Consultation Response from KC, Lead Local Flood Authority
2025/91781 Bradley Villa Farm, Bradley Road, Bradley, Huddersfield, HD2 2JY
Discharge of details reserved by conditions 9 (cycle parking), 10 (electric vehicle charging), 11 (waste storage and collection), 12 (temporary drainage), 13 (drainage scheme), 14 (flood routing), 15 (Phase II report), 19 (external materials), 20 (boundary treatments), 21 (external lighting), 23 (BNG assessment) and 24 (Biodiversity Gain Plan) of previous permission 2023/92887 for change of use of egg production unit to research and development or industrial uses falling within E(g)(ii) and (iii) Use Class, and associated elevational alterations and provision of access, gates, forecourt, parking areas and landscaping
Date Responded: 2nd March 2026 Responding Officer: Paul Farndale Responding Ref: 2

Condition 13 – General Drainage.

TITLE		ATTENUATION BASIN SECTIONS	
PROJECT		BRADLEY VILLA FARM	
CLIENT		MR R KERSHAW	
DRAWING STATUS		PRELIMINARY	
Scale	Date	Drawn	CR
1:250 @ A1	MAR 26	Chk.	MI
Drw. No.	2489/01/SK04		Rev

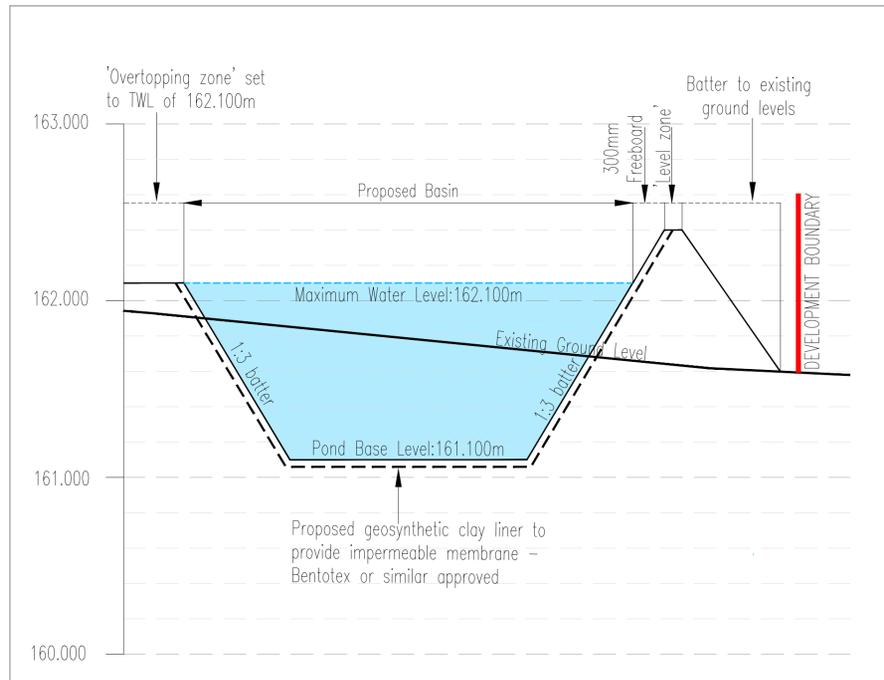
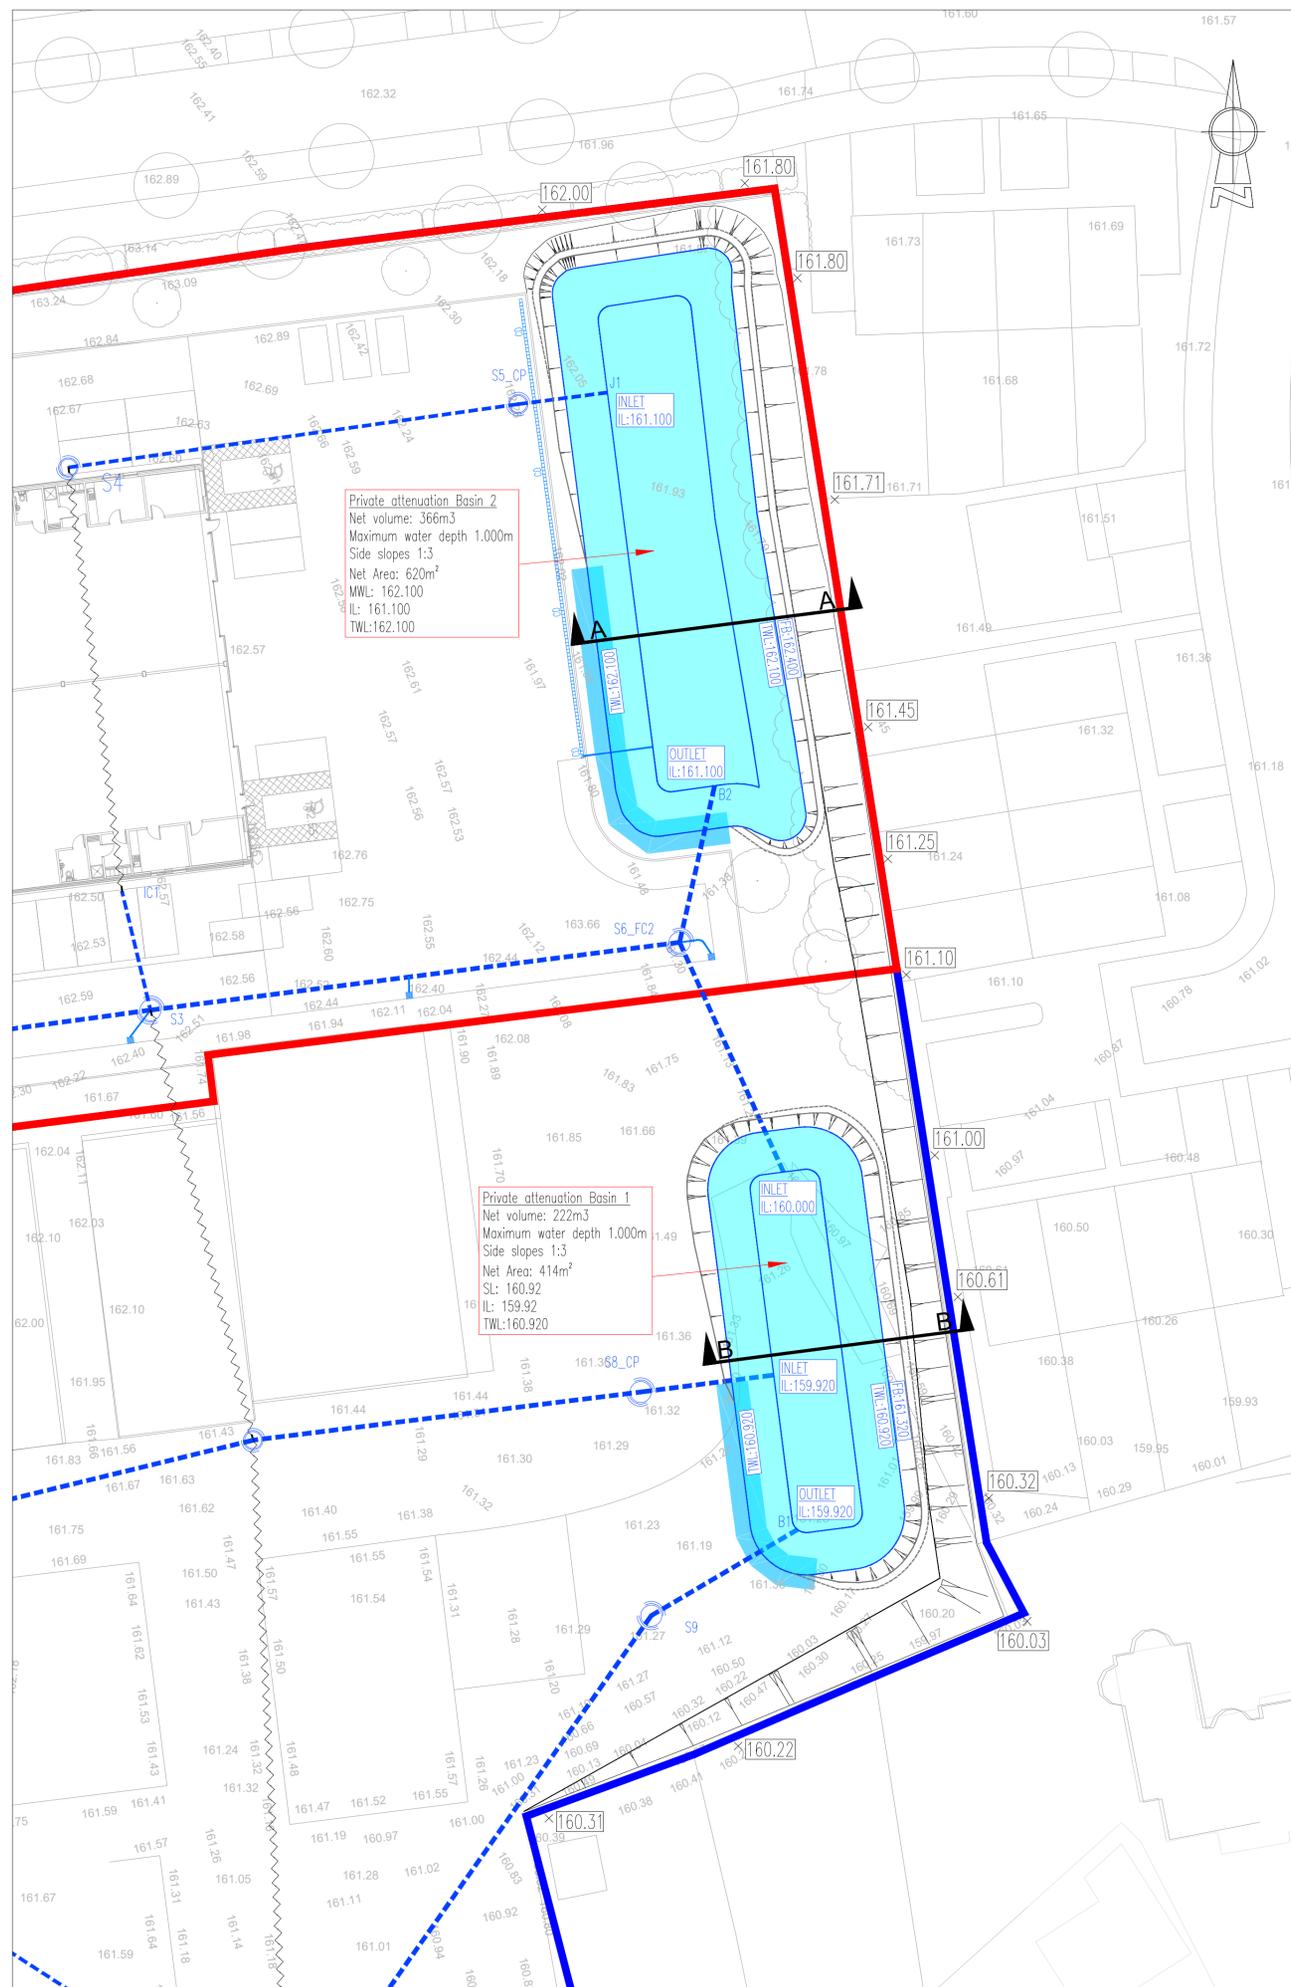
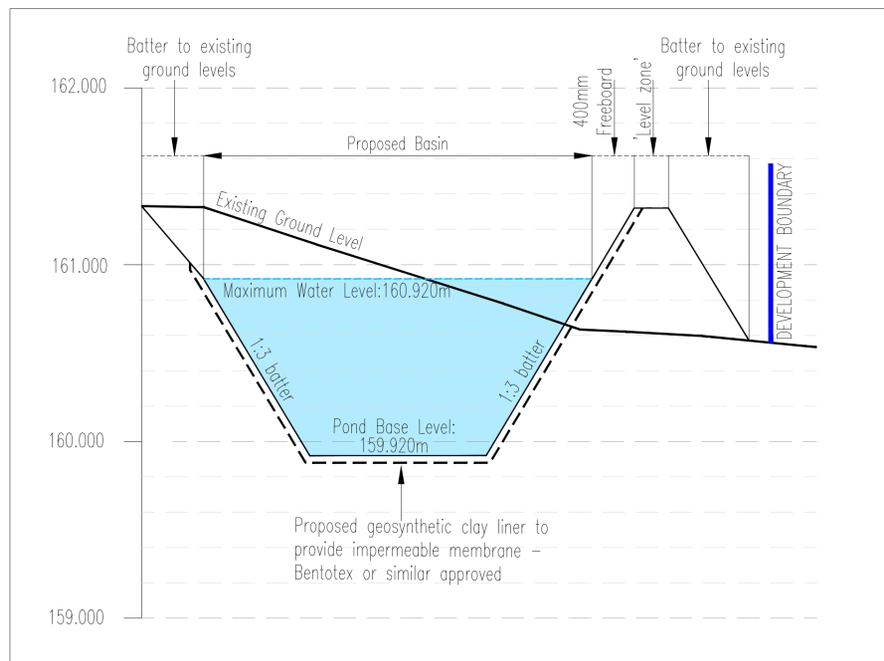
A plan and cross section of how the basins are designed and constructed including inlet and outlet levels, slope gradients and water levels and materials used (e.g. clay, liners etc).

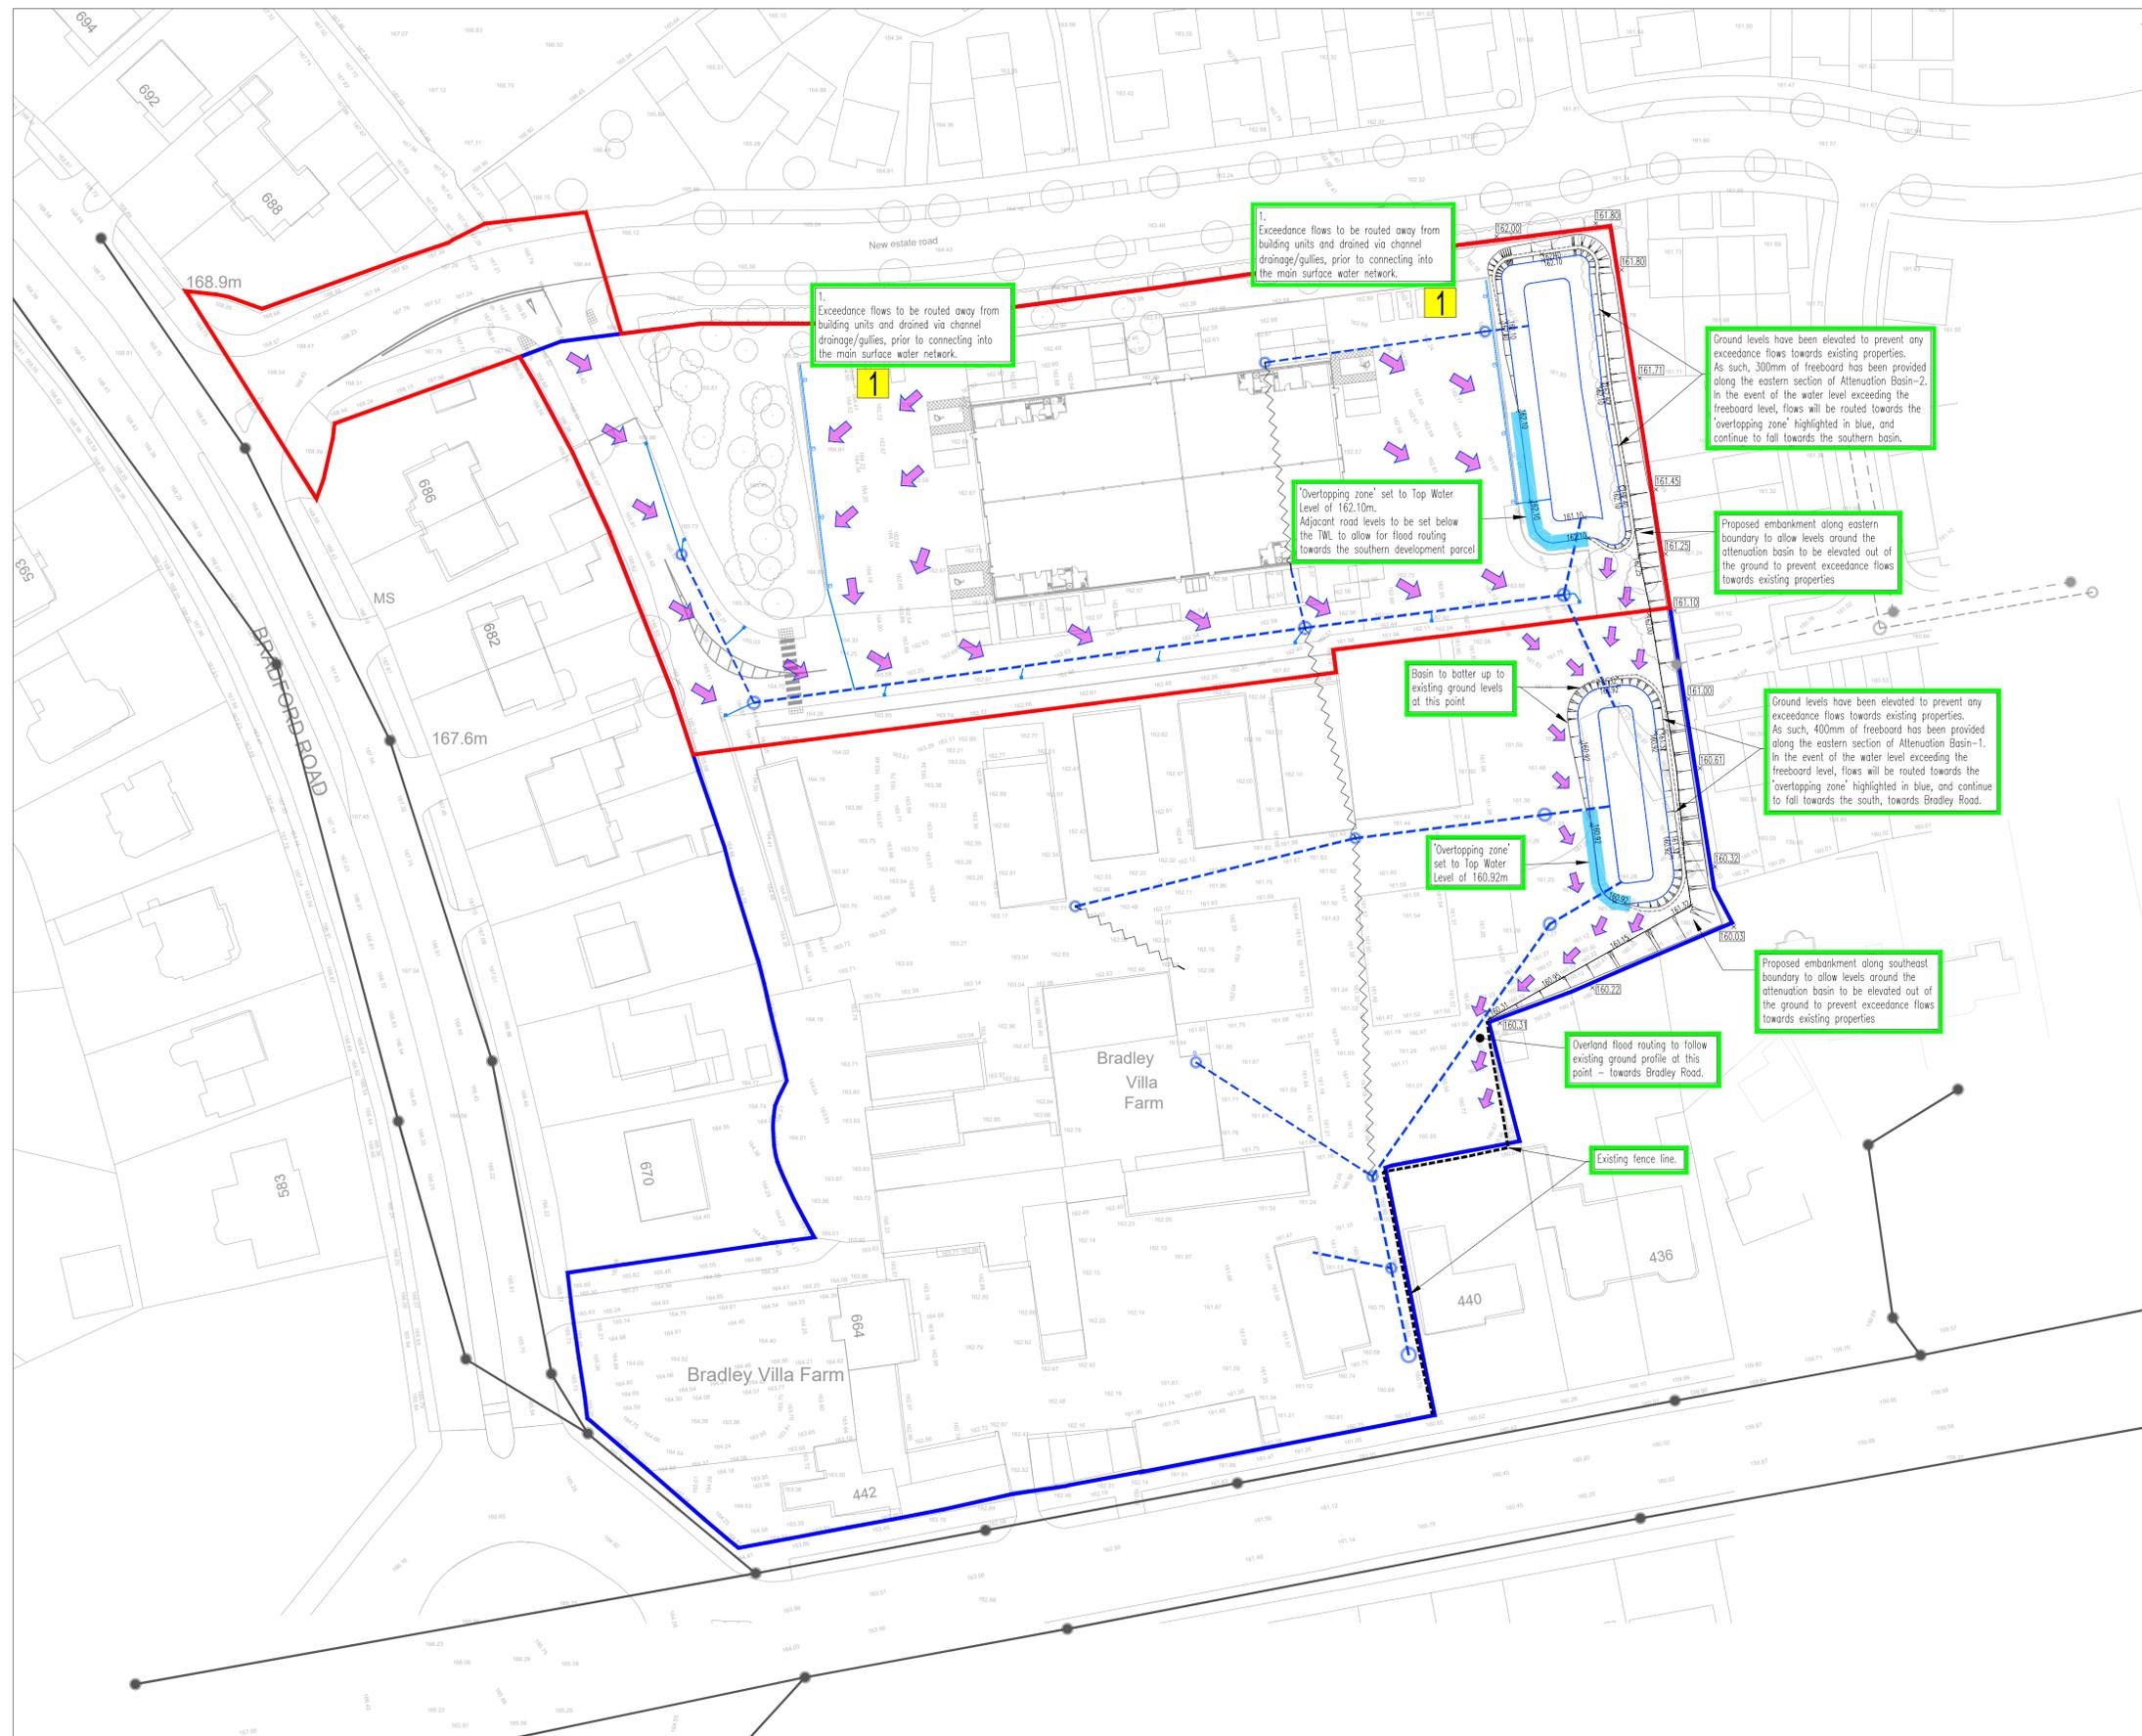
Nothing has been supplied to discharge the condition. The site naturally falls to the southeast. We recommend that boundary treatments are examined to mitigate flood risk in an exceedance event or blockage scenario where reasonably practicable.
